April 13, 2009

Re: 978 Washington Avenue – 161 E003 – R-5 – Change of use to place of worship –
Permit #09-0161

I am in receipt of your application to change the use of the first floor of 978 Washington Avenue from a television repair shop to a religious use/place of worship. At this point I cannot approve your permit because it does not meet all the zoning requirements for the R-5 zone.

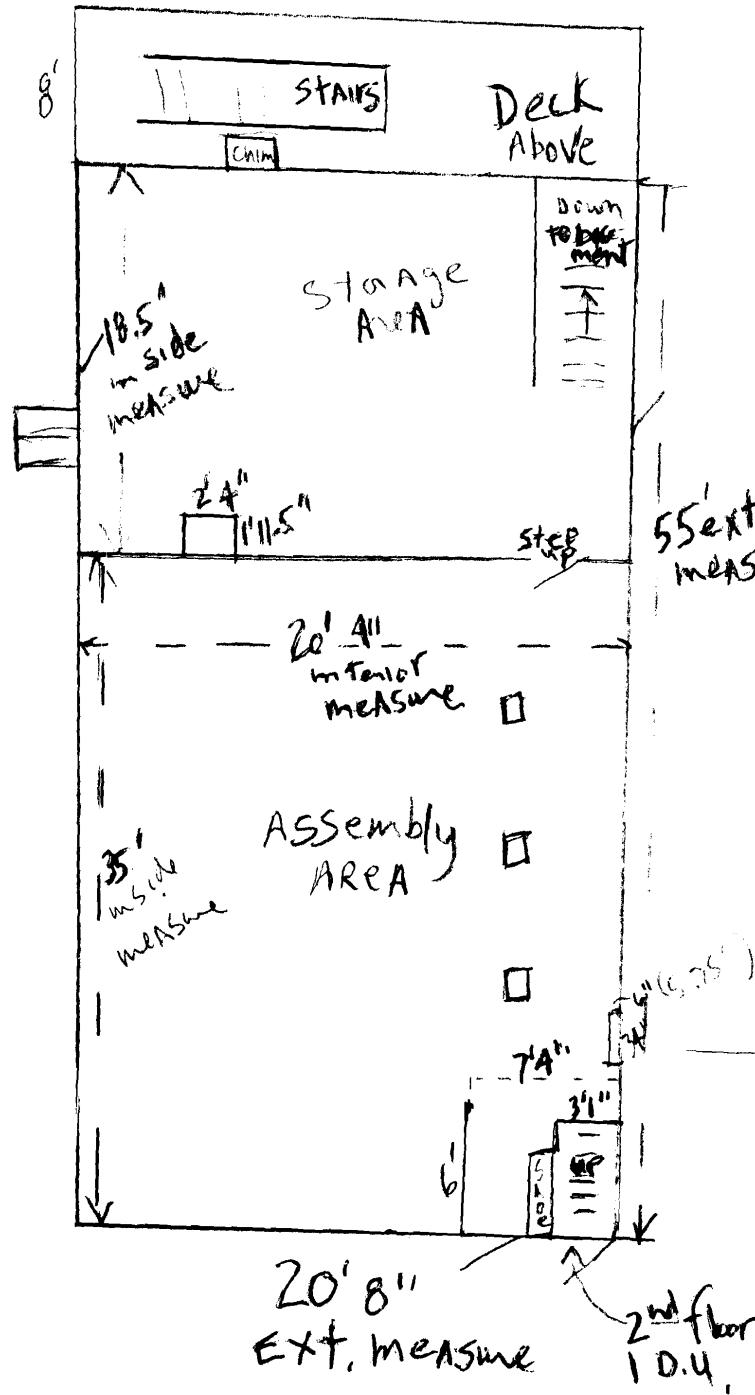
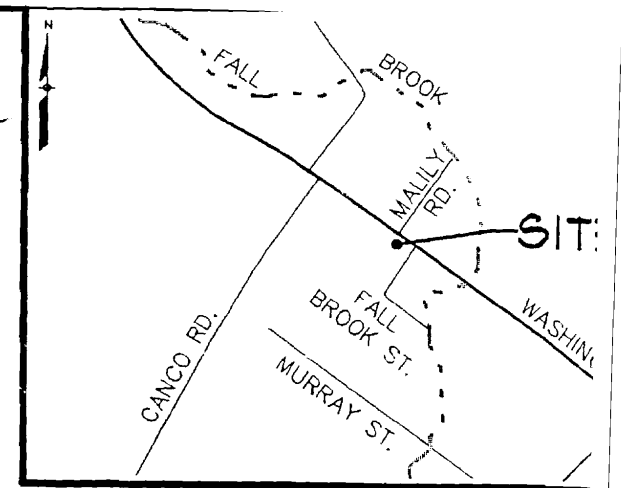
The second requirement is that when there is a change of use, you need to meet the minimum parking requirements for the use of the building. Your parking plan shows that you have twenty off street parking spaces. You need a total of forty off-street parking spaces, thirty-nine parking spaces for a place of worship/religious use [section 14-332(k)] and one parking space for the existing dwelling unit on the second floor [section 14-332(a)(2)]. You need to apply for a variance with the Zoning Board of Appeals since you do not have the required number of parking spaces.

If you are granted these two variances, your next step is to apply for a conditional use under section 14-118(b)(3) and your submitted site plan for the expanded parking lot must be revised and completed for review. The Planning Board is the reviewing authority for the conditional use appeal and the site plan. A copy of the site plan ordinance is attached. The submittal requirements for a complete application are found in section 14-525.
